CITY OF ALBUQUERQUE
PLANNING DEPARTMENT
DEVELOPMENT REVIEW BOARD

DRB CASE NO: 1002202

April 2, 2014
DRB Comments

RE: Parcel C-2A, Winrock Center

DAVE & BUSTERS
25,200 SF
BAR, RESTAURANT, ARCADE

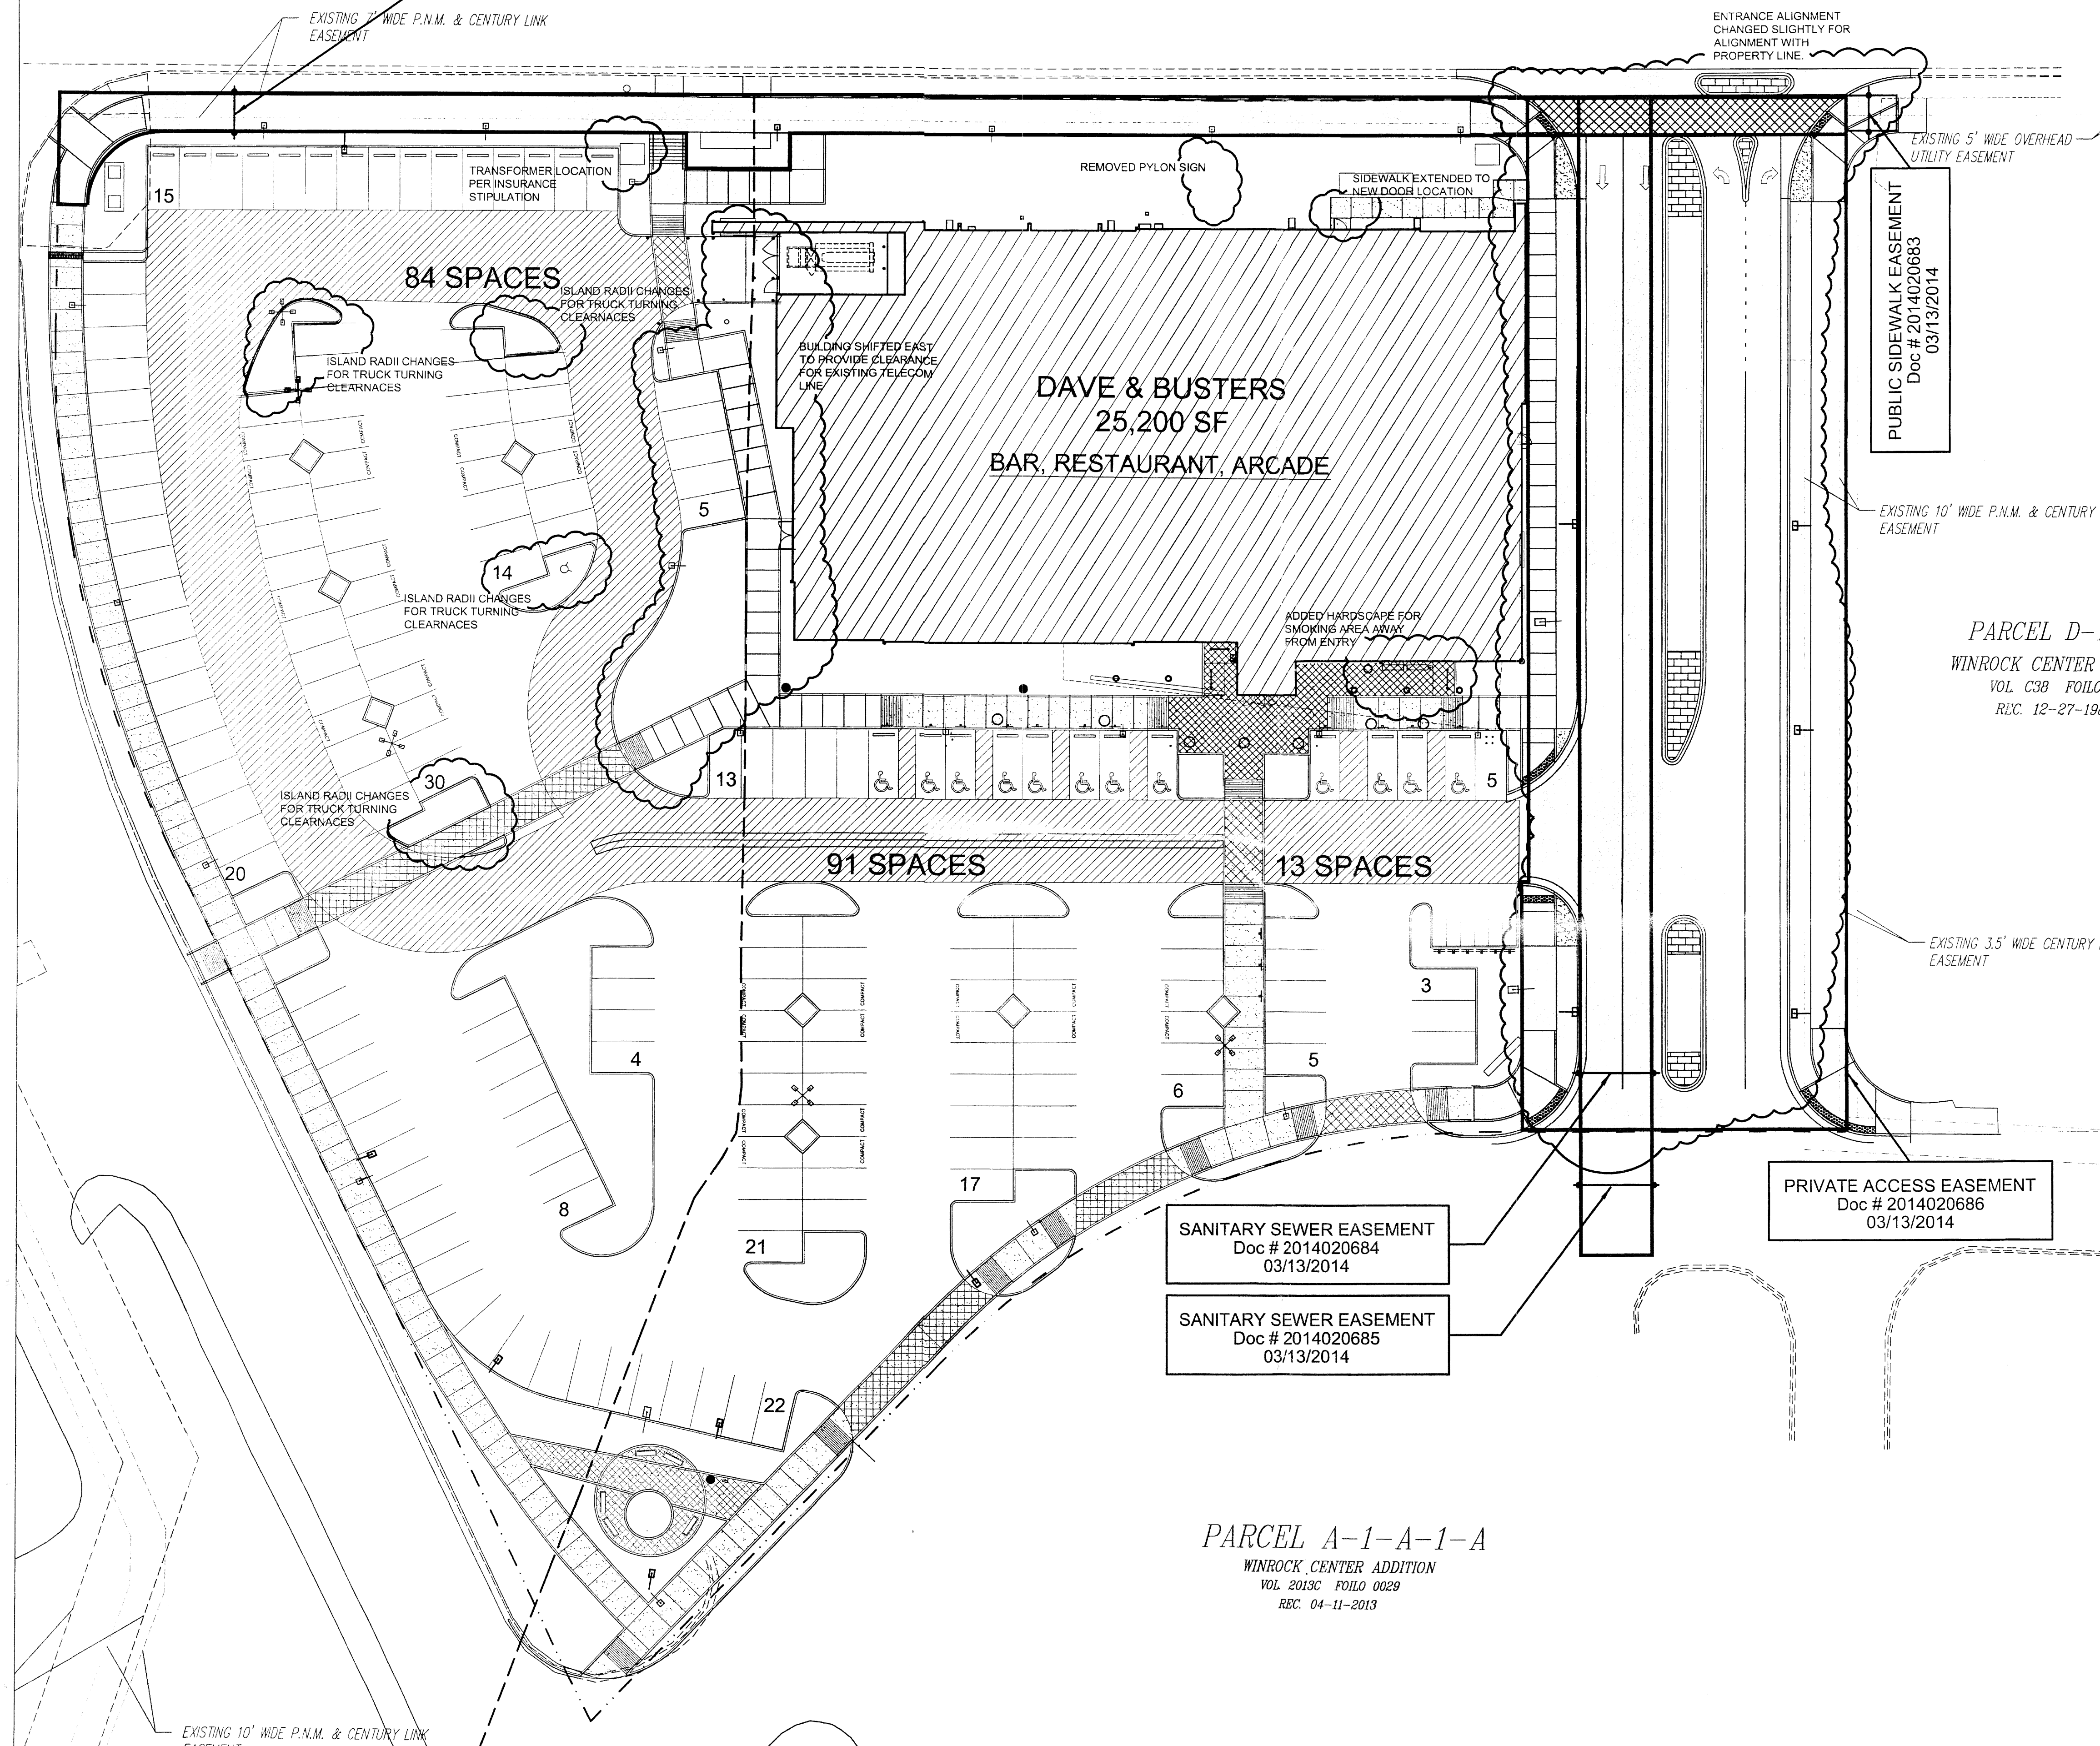
Proposed small parking lot parcel is not consistent with the Purpose and Intent of the Subdivision Ordinance for orderly development of land by virtue of the small strip of land between the building lot and the street, nor is it appropriate or suitable to subdivide a small parcel for parking only.

If a new lot is desired to be created for the proposed building only, the parking lot needs to be incorporated into adjacent Parcel A-1-A-1.
